WHITE BAY 6 MARINE PARK

Application No. MP 06_0037

We live in the adjacent block of flats in Grafton Street and write concerning *Modification Request of the Refuelling & Supply facility at White Bay*.

Proj No. | Scale at A3 | Drawing No | Issue
 | 1:1000 | DA1002 | 07

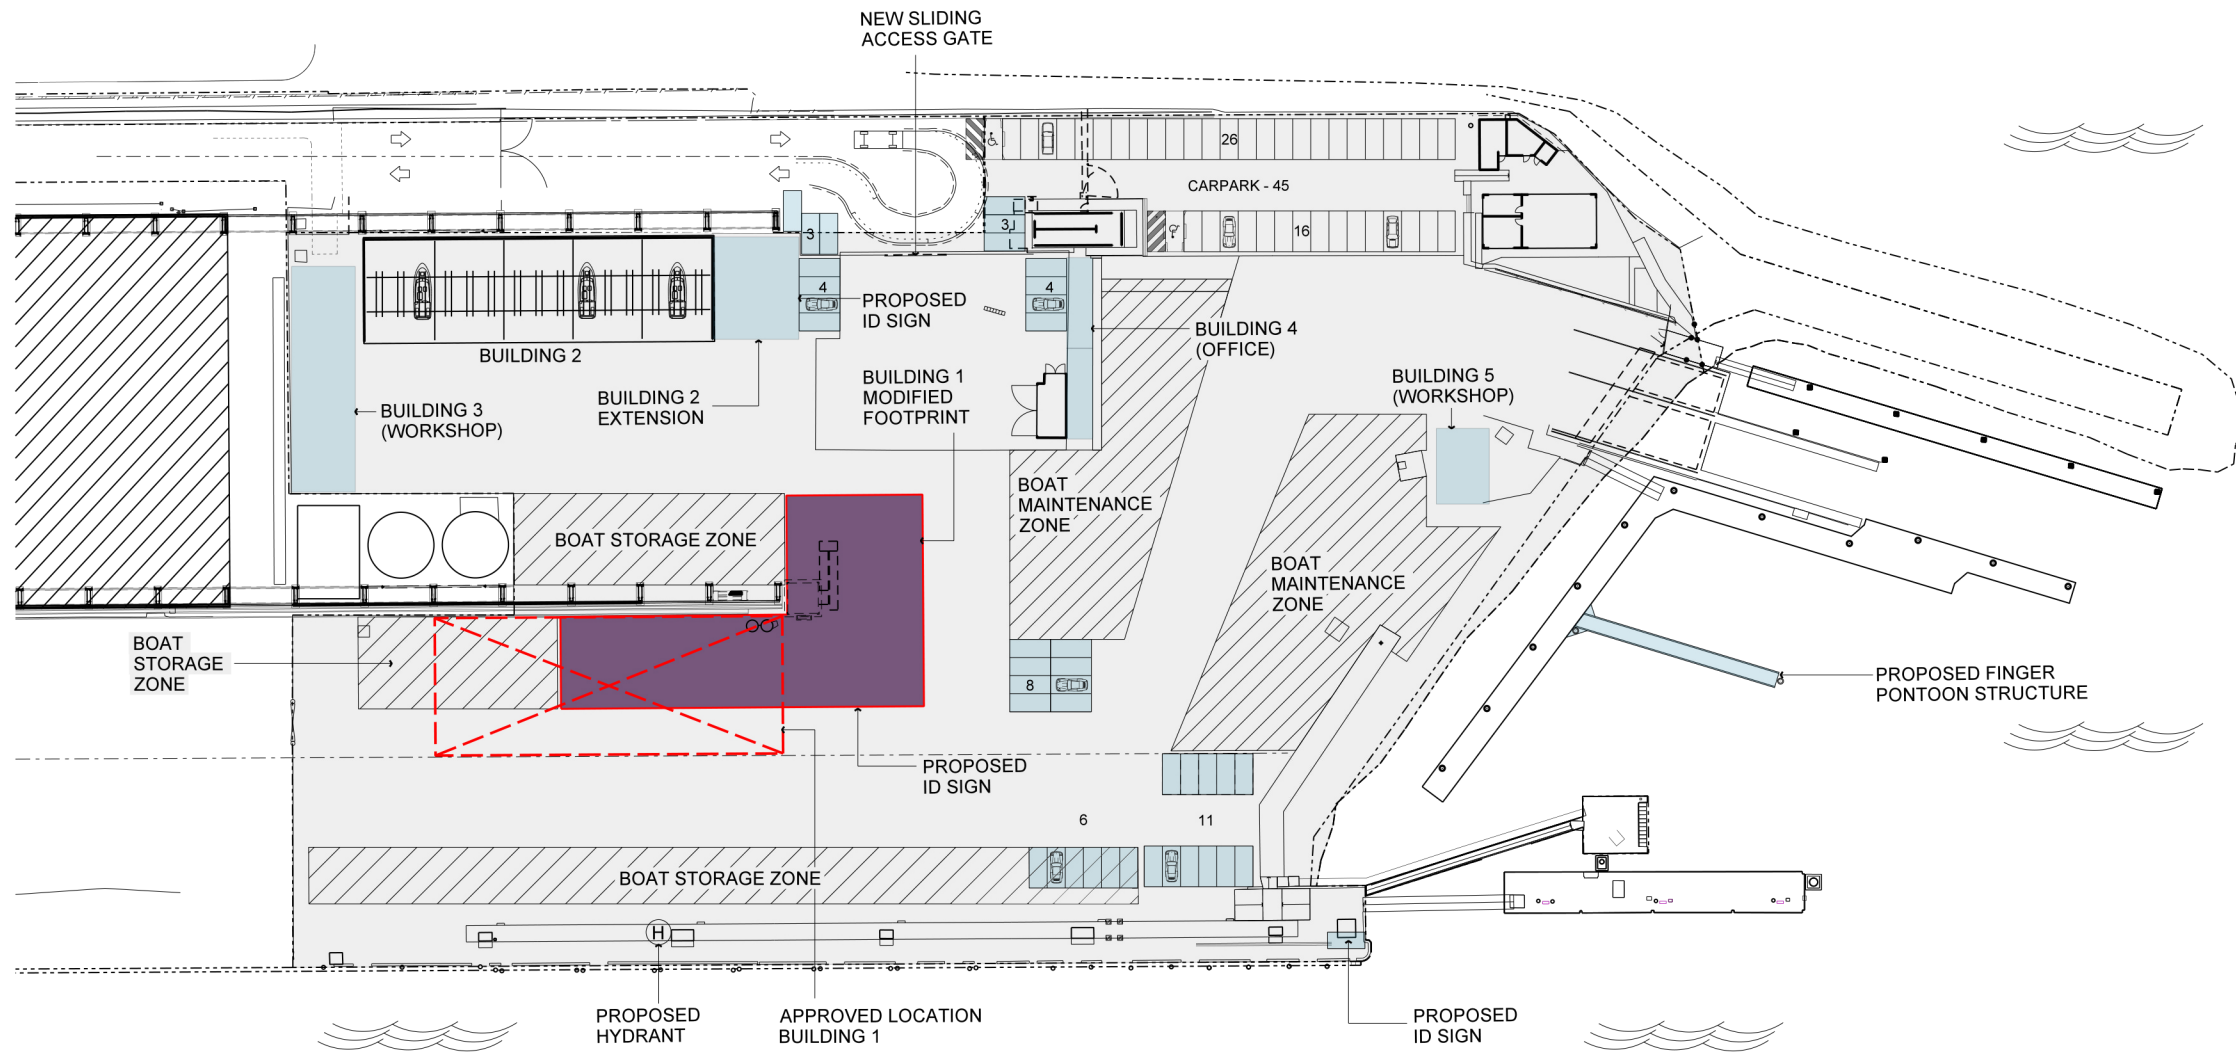
- 1) Building I modified footprint results in a major intrusion to our view to the south which the approved location avoids.
- 2) The Building 3 and Building 2 extension shown on the Alternative Site Plan (Drg. DA 1003) will have a similar effect.
- 3) The proposal to extend operating hours without quantification of the amount of extension is unacceptable. This boat yard is adjacent to many residences and the propose additional boat storage space will inevitably put pressure on working hours. If there is any sort 'good neighbour' intention on the part of the proponents working hours must be strictly limited and policed.
